Local Policing Support Team

Your Ref: AW/232/19/OUT

Date 17th September 2019

RE: 19 & 21 Nyewood Lane, Aldwick PO21 2QB

DRAWN BY		DATE		SCALE		SHEET NO.	
P. BRESNAHAN	K. RICHARDS	19 - 21 NYEWOOD LANE	ILLUSTRATIVE	1:100	A2	5	5
PROJECT NAME		SITE PLAN		DATE		SHEET NO.	
19 - 21 NYEWOOD LANE		ILLUSTRATIVE		DATE		SHEET NO.	
BROOKING RECS		SITE PLAN		DATE		SHEET NO.	
06.08.2019		1:100		A2		5

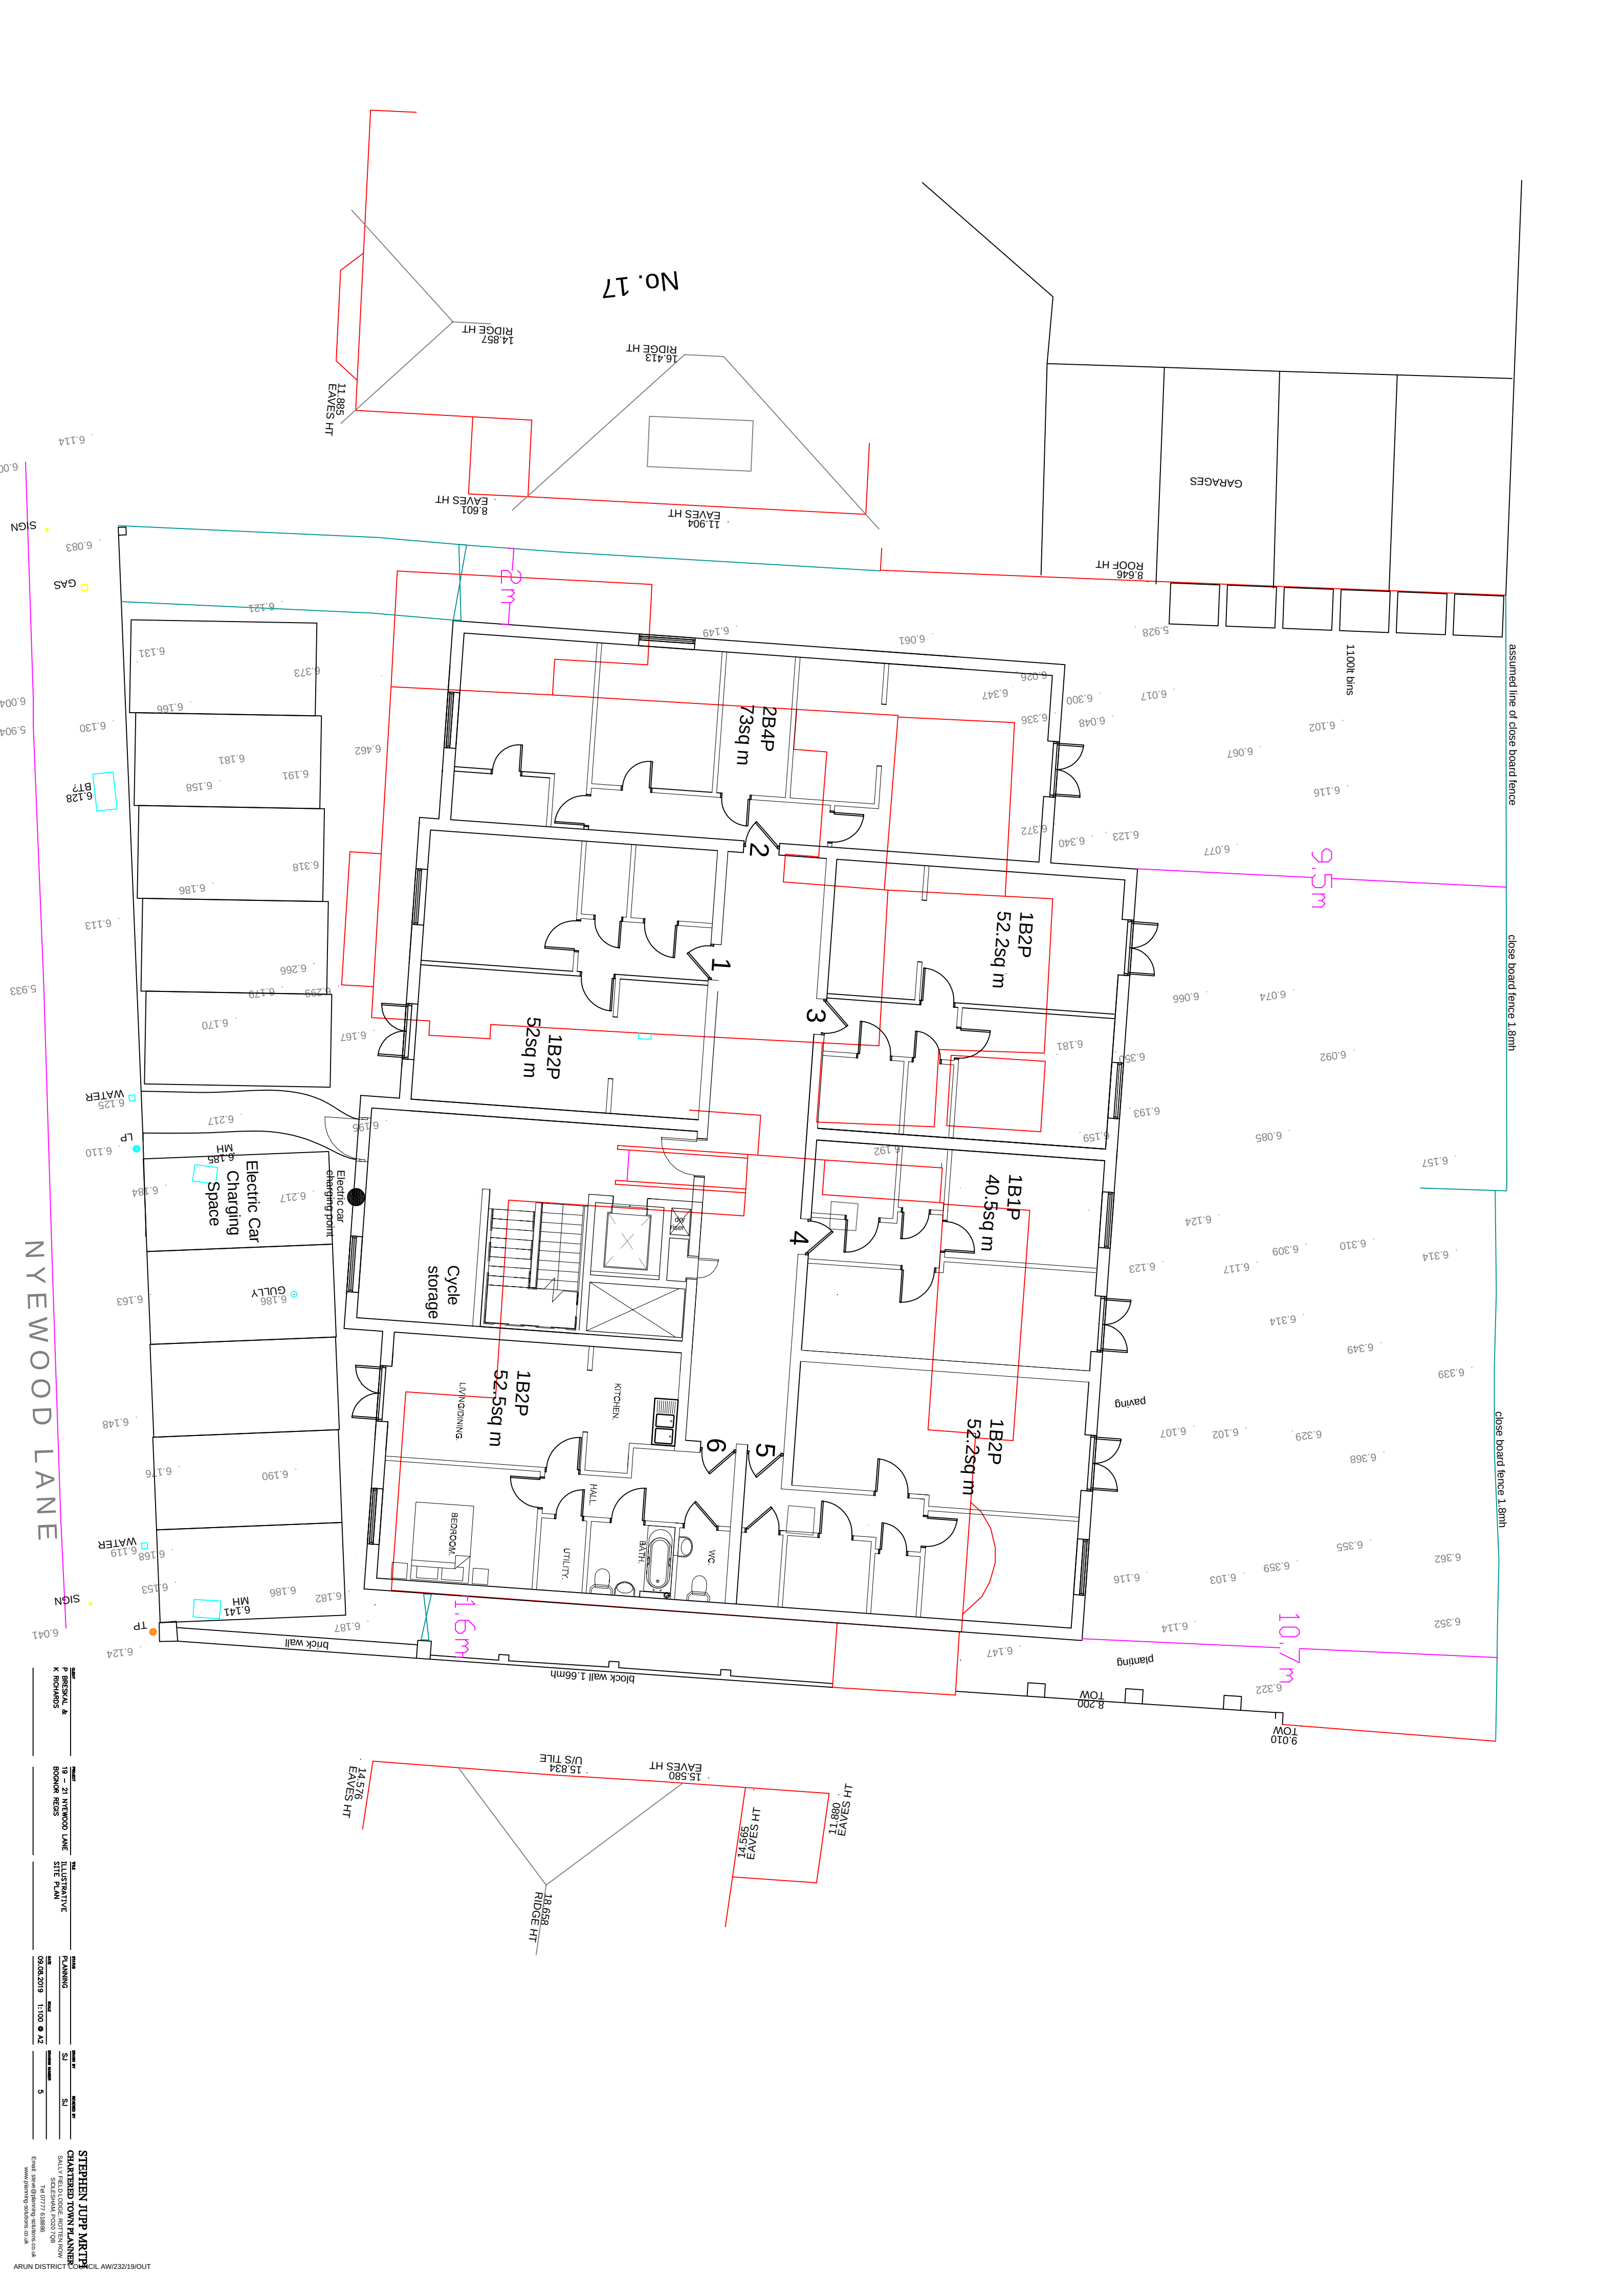
I have a concern that the dwelling located on the ground floor in the front right of the development could suffer from vehicle exhaust fumes entering the front living room window if a car reverses back to the wall or alternatively, if driving forward, the car driver will be able to view into the private residence.
